Our ref: DOC22/366094

Your ref: SSD-13855453

**Grenfell Poultry Breeder Farm – Response to Submissions**

CHECKED BY
N.B.

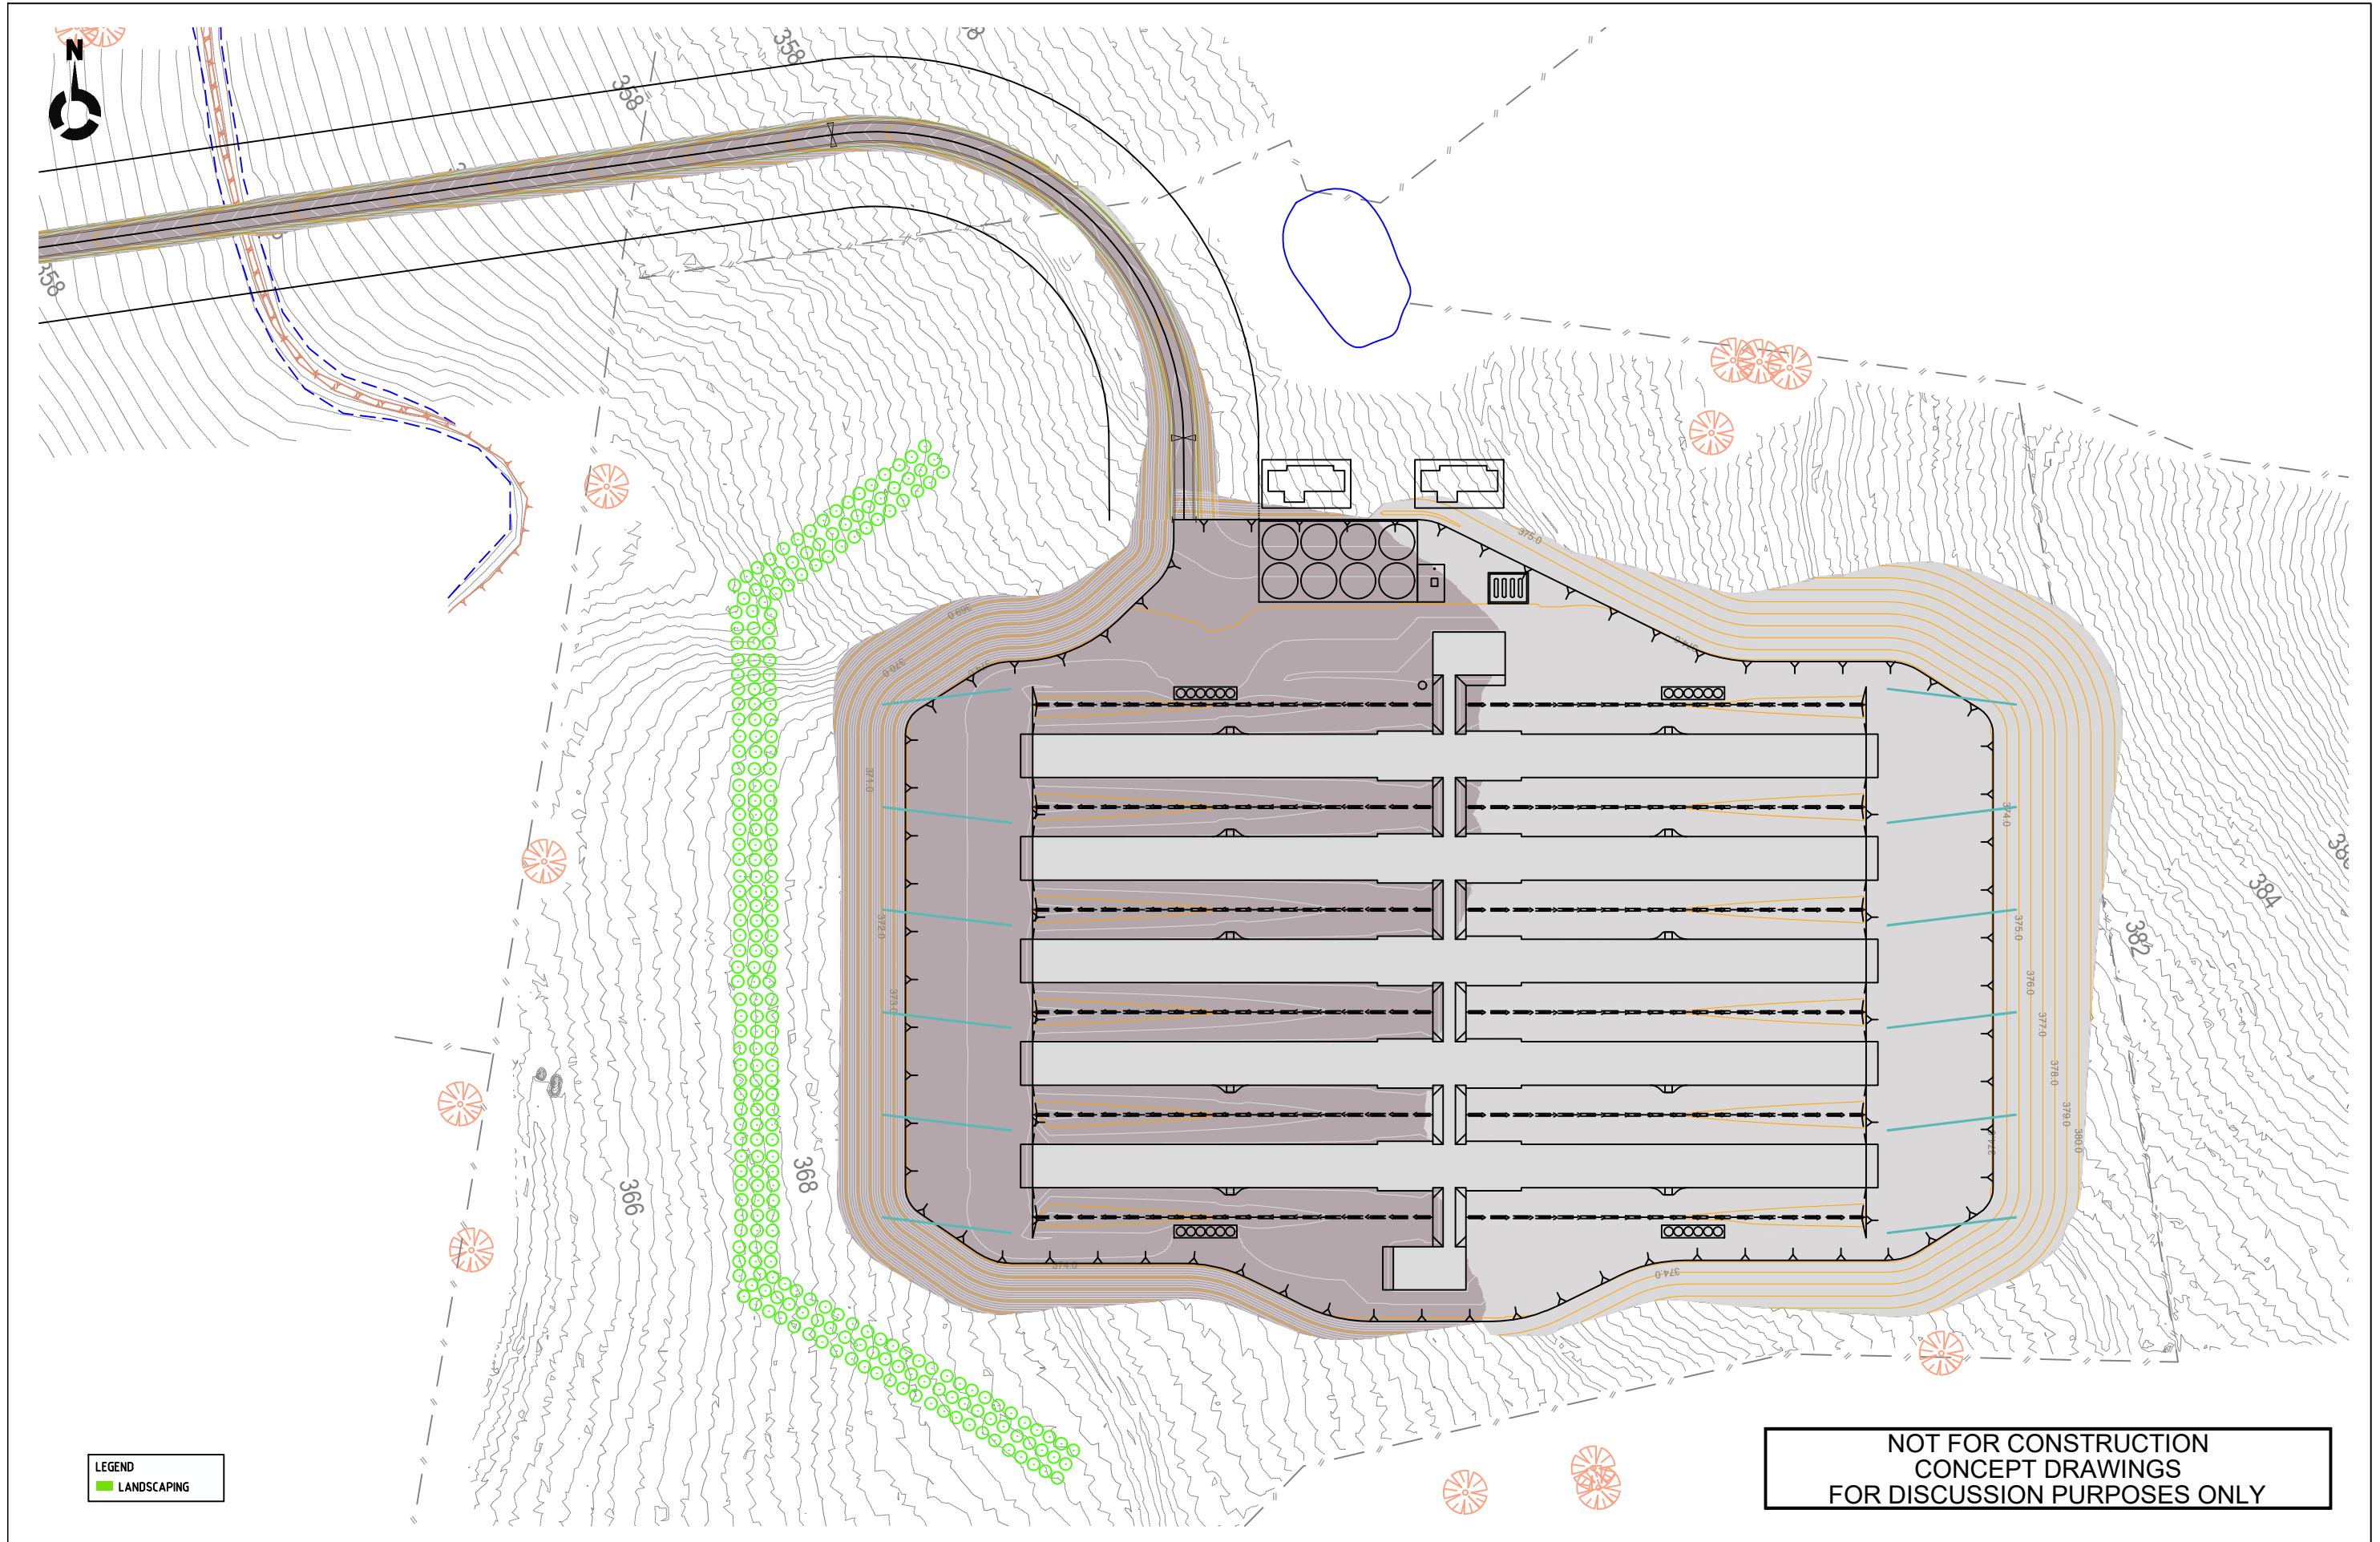
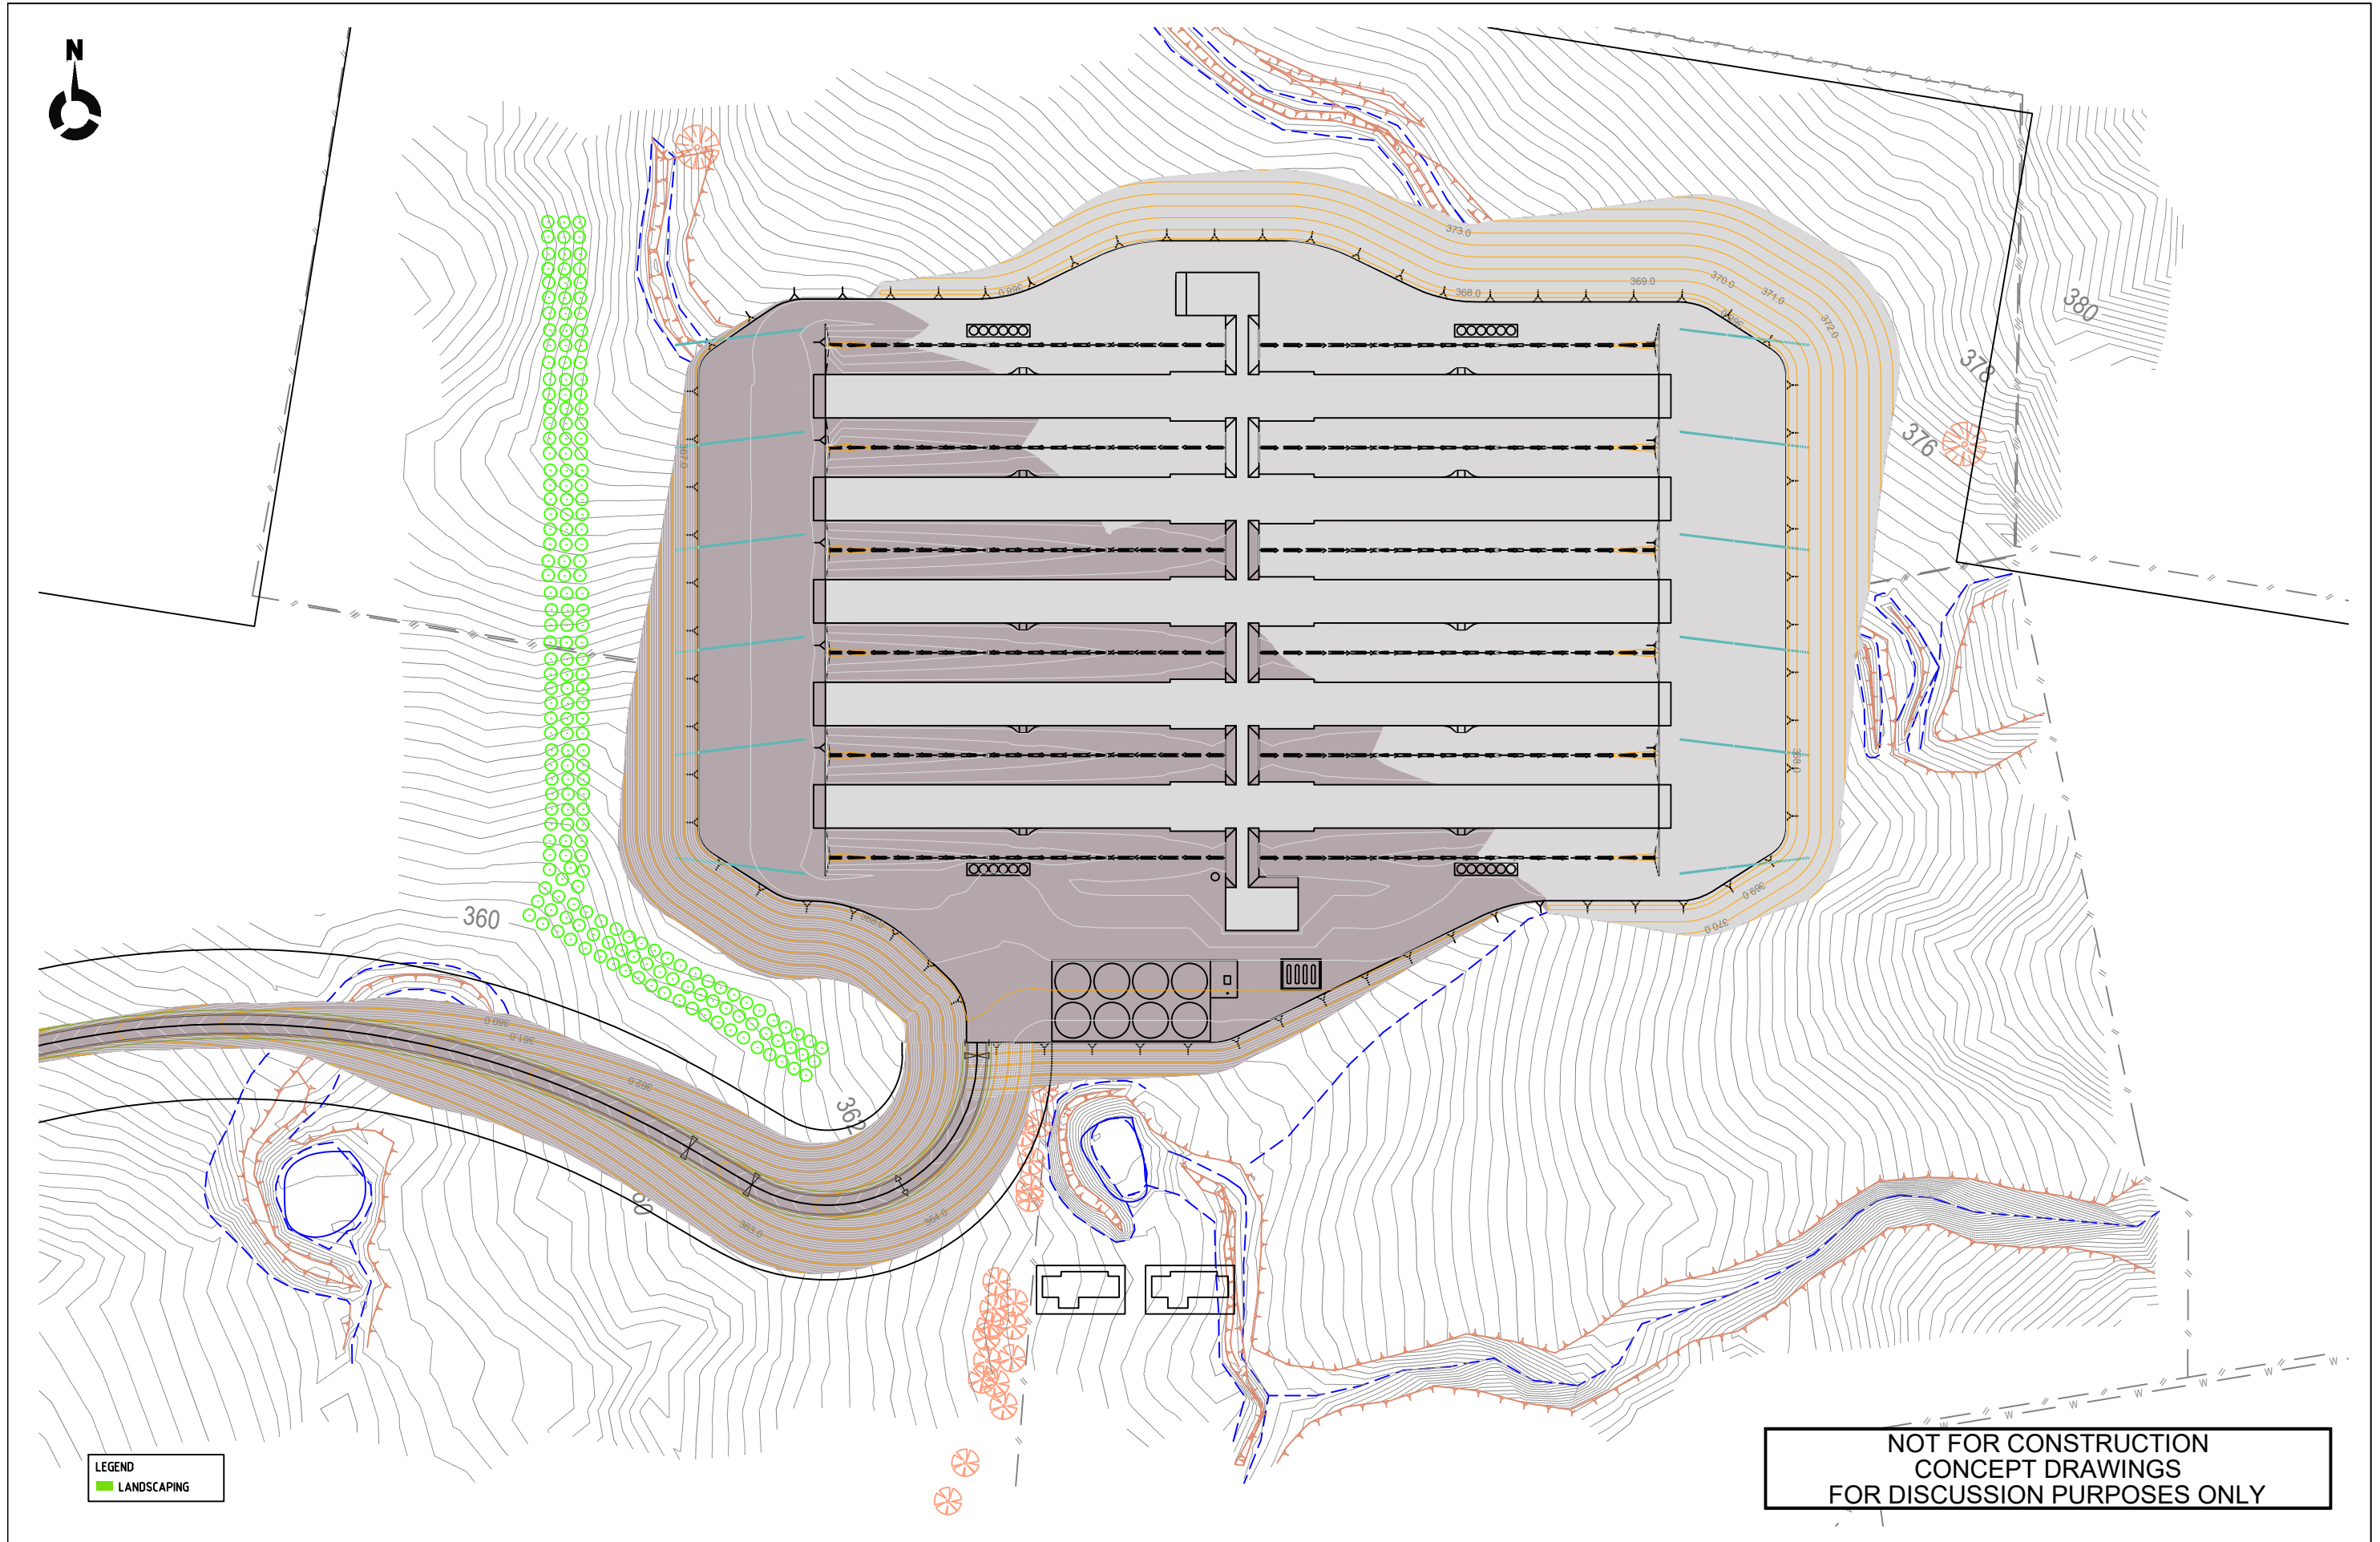
The updated concept plan for the project site submitted by the proponent includes a 25m road buffer and road widening within the site entry point from Gooloogong Road. BCS notes from review of the concept plan that these design changes may require additional clearing of biodiversity values which have not been included within the Biodiversity Development Assessment Report (BDAR) or the projects associated offset calculations.

BCS recommends that both the BDAR and the projects offset calculations are updated to include the abovementioned project design changes. If the total clearing required for the proposed design changes are conceptual and/or uncertain at this point in time, BCS recommends that the upper quantum of vegetation clearing required for the project is assessed and calculated, according to a worst-case scenario.
